Application No: K/54/21/PL
Site Address: Moorings Gorse Avenue East Preston BN16 1SQ
Description of works: Variation of condition imposed under K/58/20/HH relating to condition 2-approved plans.

Thank you for your internet representation made on 14th January 2022 which has been recorded as an objection with the comments as follows:

We wish to raise the following objections to the development plans submitted by Moorings.

Drawing no. **KG/GA/06**

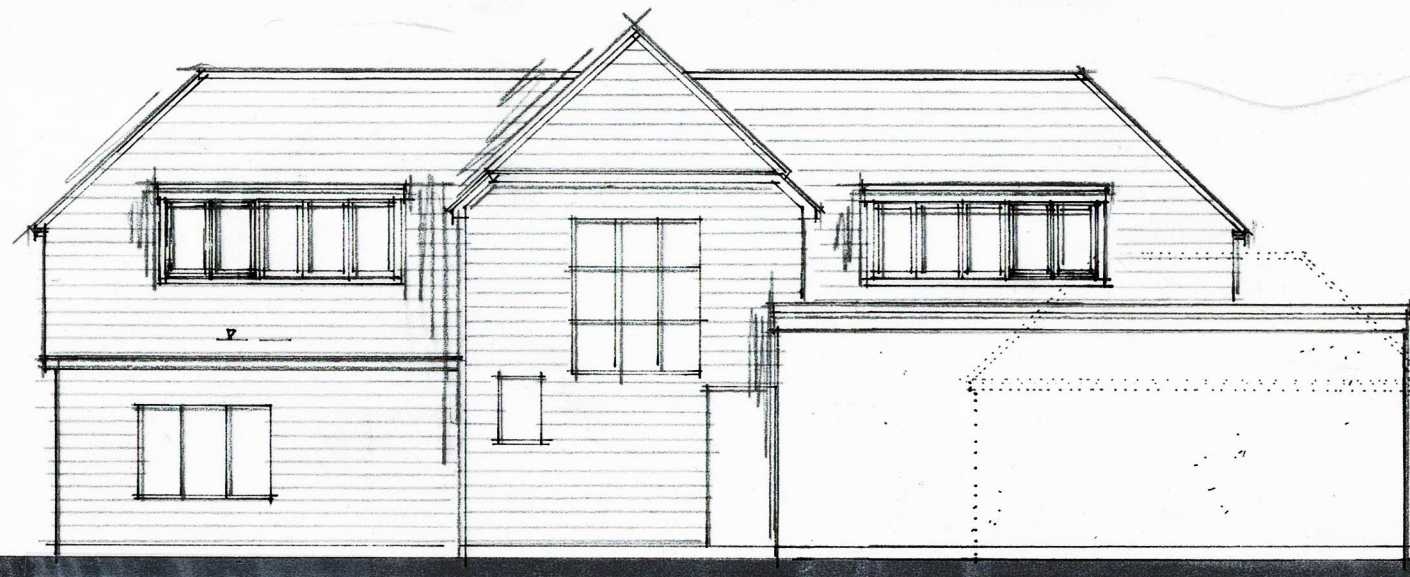
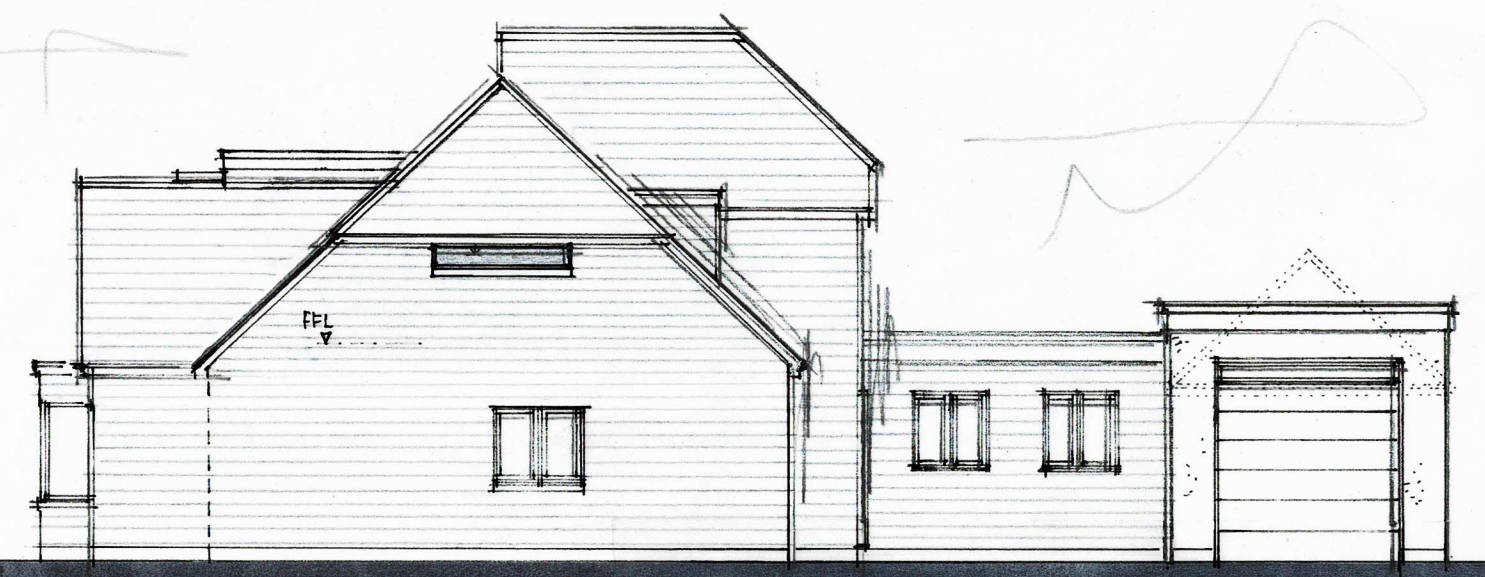
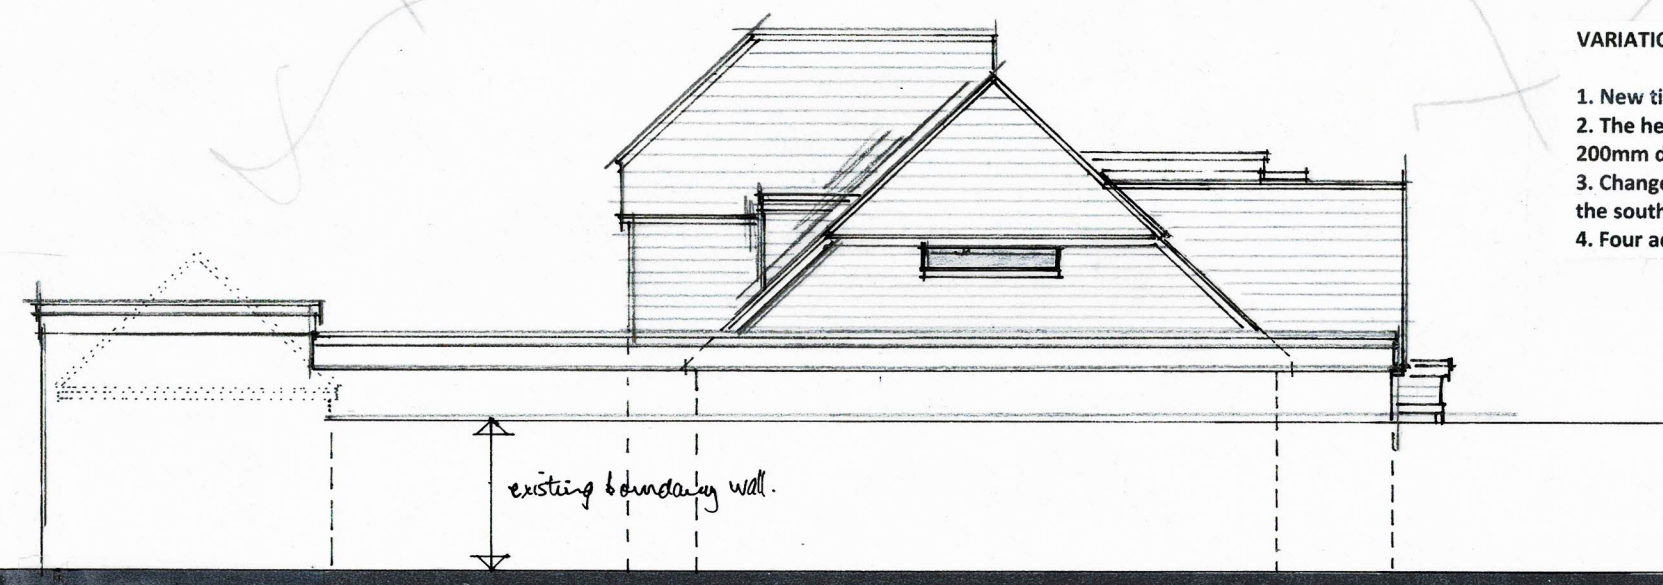
The increase in size of the flat roofed dormer window which can be seen from both Highwater House and the twitten which significantly increases the bulk of the West and East Elevation (compare with Side Elevations shown on drawing KG/GA/06 rev E)

The increased height of the First Floor flat roofed central bay window on the South elevation over and above the gable ridge heights (by approx. an additional 300mm)

An alteration in the West facing window - now a larger horizontal window with no obscure glass - which directly overlooks Highwater House.

The addition of a window on the North elevation (compare with approved drawings)

The significantly increased fascia board on the flat roofed garage

- The new timber shingles are detrimental to the street scene and do not reflect the character of the original building

- The changes in fenestration are inappropriate for the scale of the property ie the W and E facing windows have the appearance of a machine gun emplacement; the flat roofed dormers are bulky and over dominant; the four veluxes are excessive in number and create a cluttered appearance; an additional window has appeared on the front elevation which is not shown on the drawings; the additional windows on the South elevation create an excessive ratio of glazing to solid wall

'MOORINGS', GORSE AVENUE, KINGSTON GORSE (D)

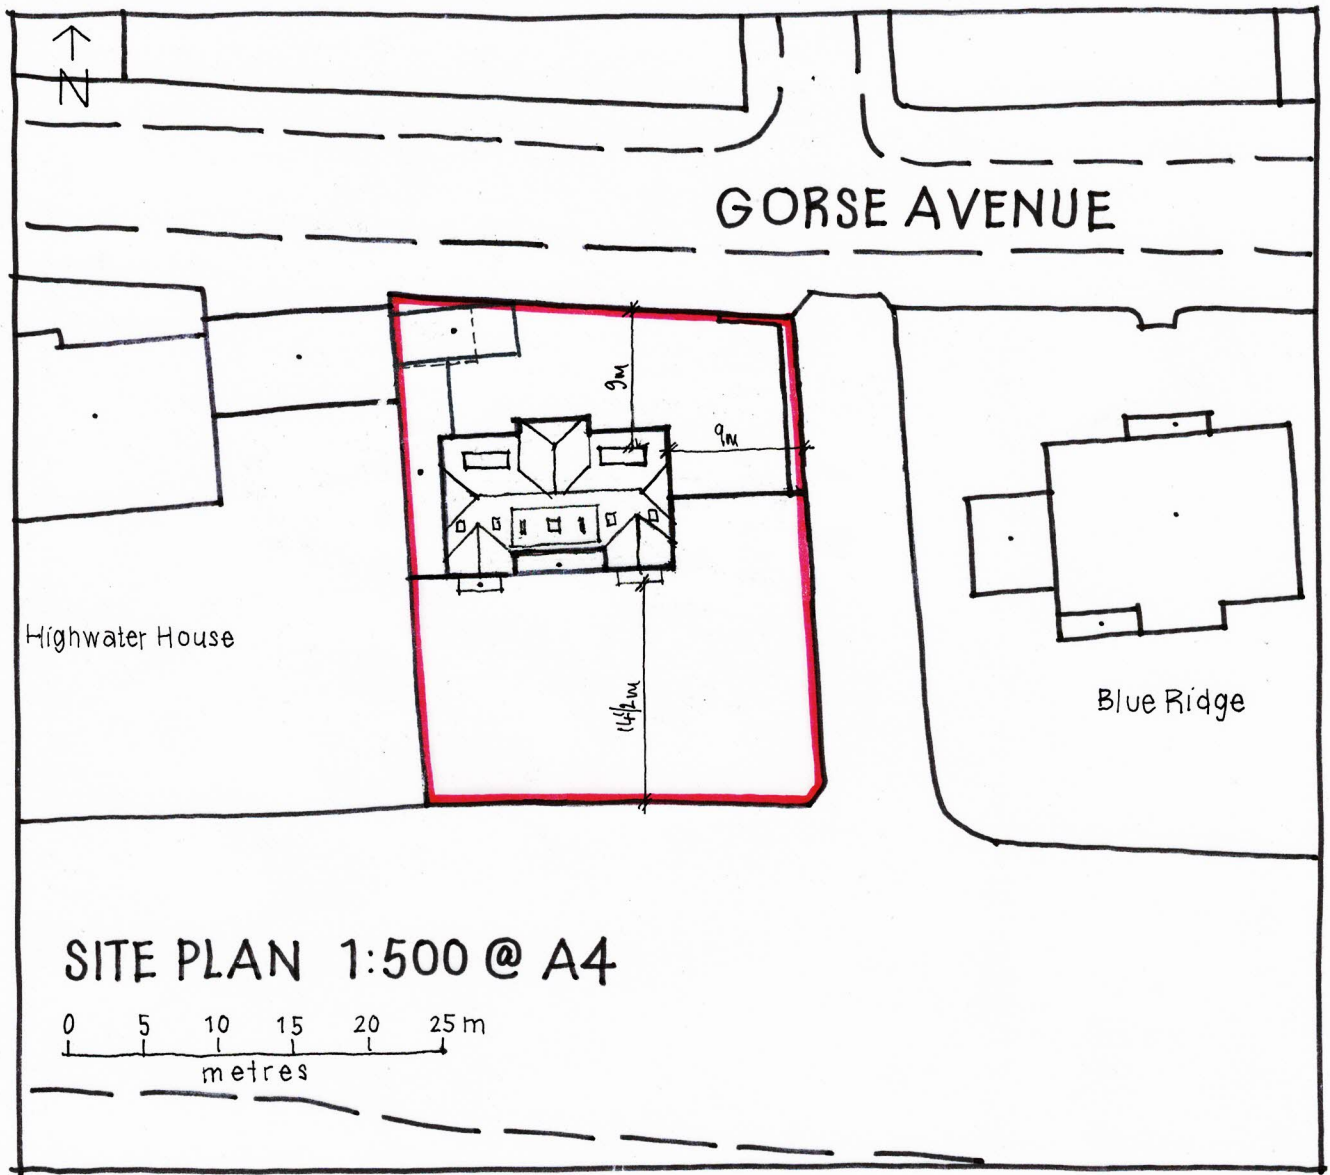
A projection beyond the line of the boundary by approx. 750mm onto the greensward created by the construction of a new perimeter wall (compare with approved location plan which shows the boundary in line with the neighbouring property). Also, the new perimeter wall to the North end of the property adjacent to Gorse Avenue has been projected beyond the line of the boundary on to the grass verge.

- The site plan does not reflect the boundary "as built" see item 1.00 above.
